ENG-PUDSP21001-R2-TIS-Redlines.pdf Markup Summary

Figure 4

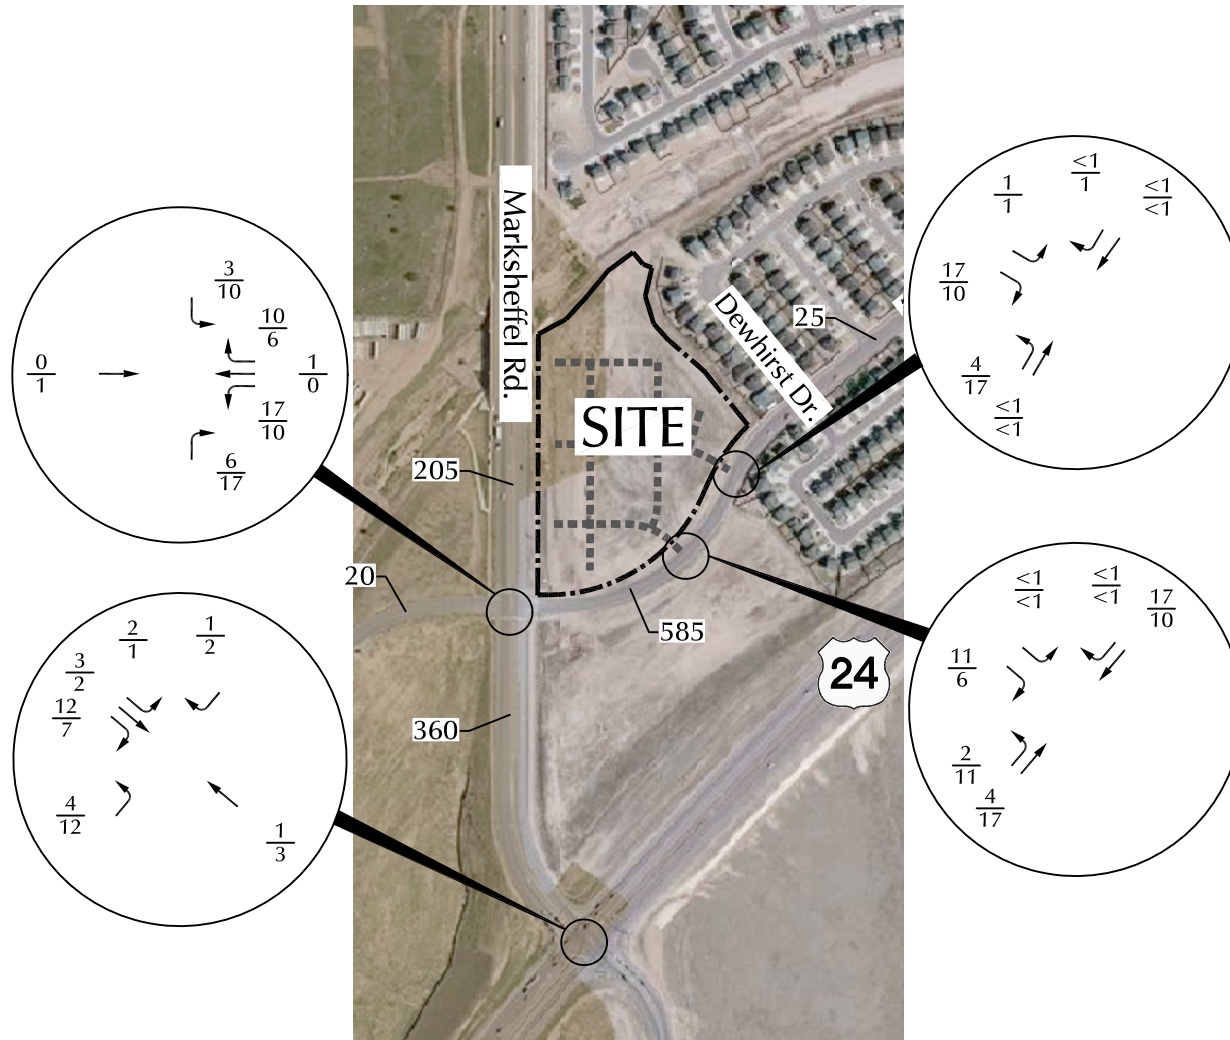
Figure 4 missing in appendix

Exhibit 1

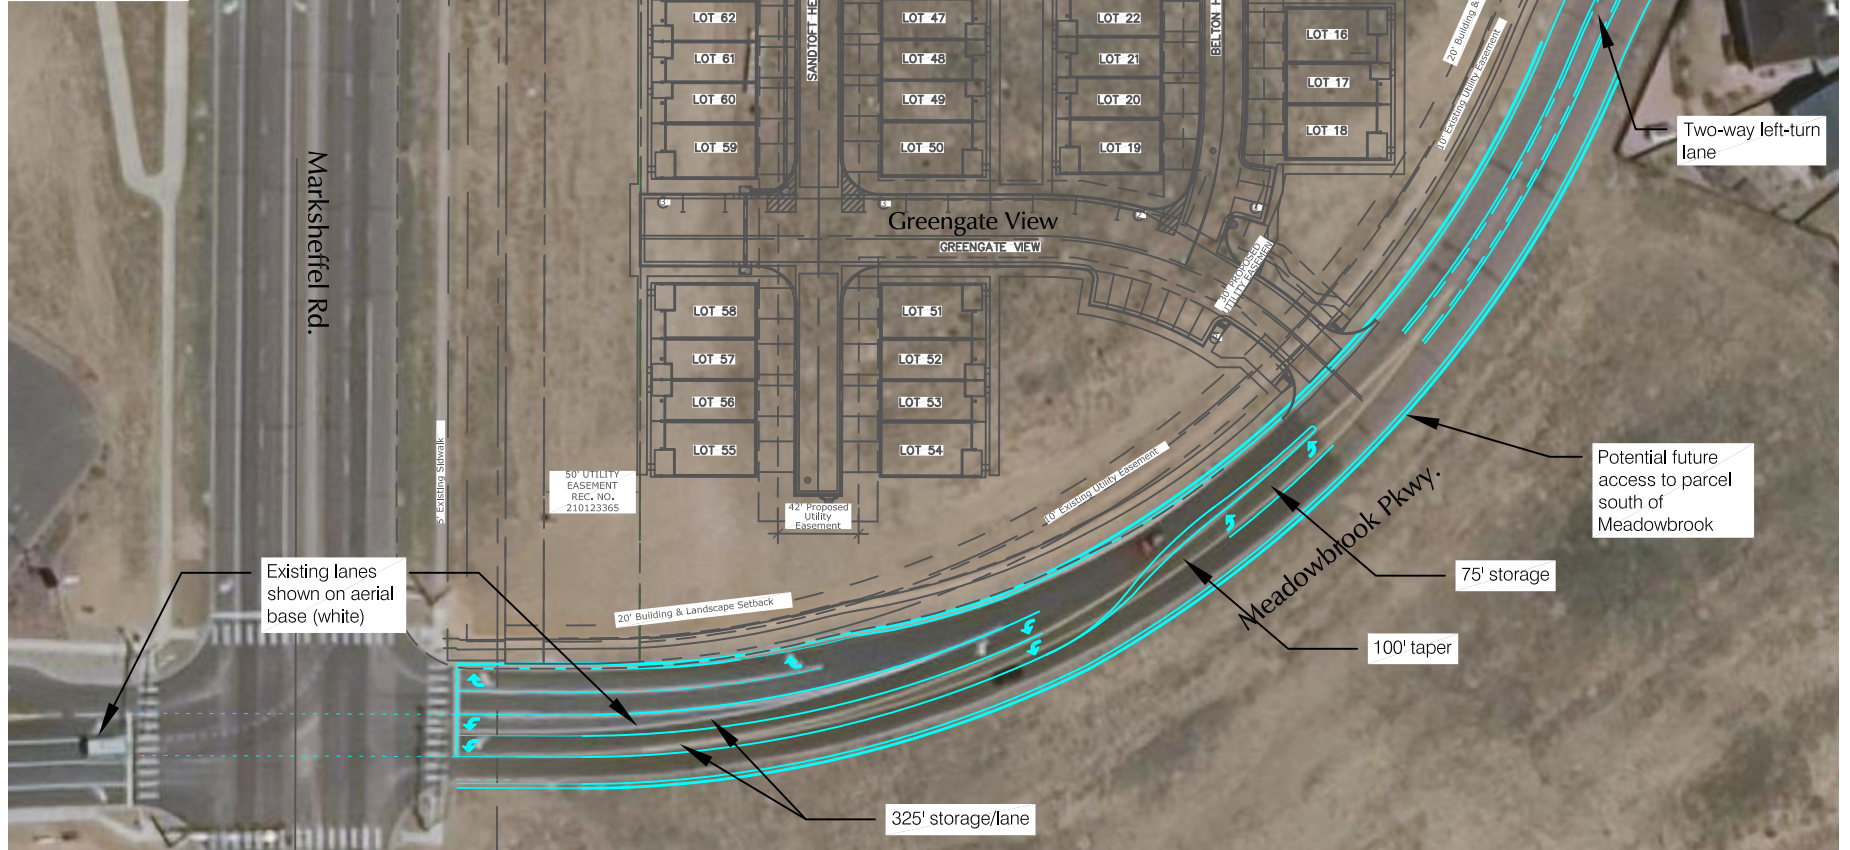
Provide exhibit to scale showing how this can be done

Provide exhibit

Please Provide exhibit
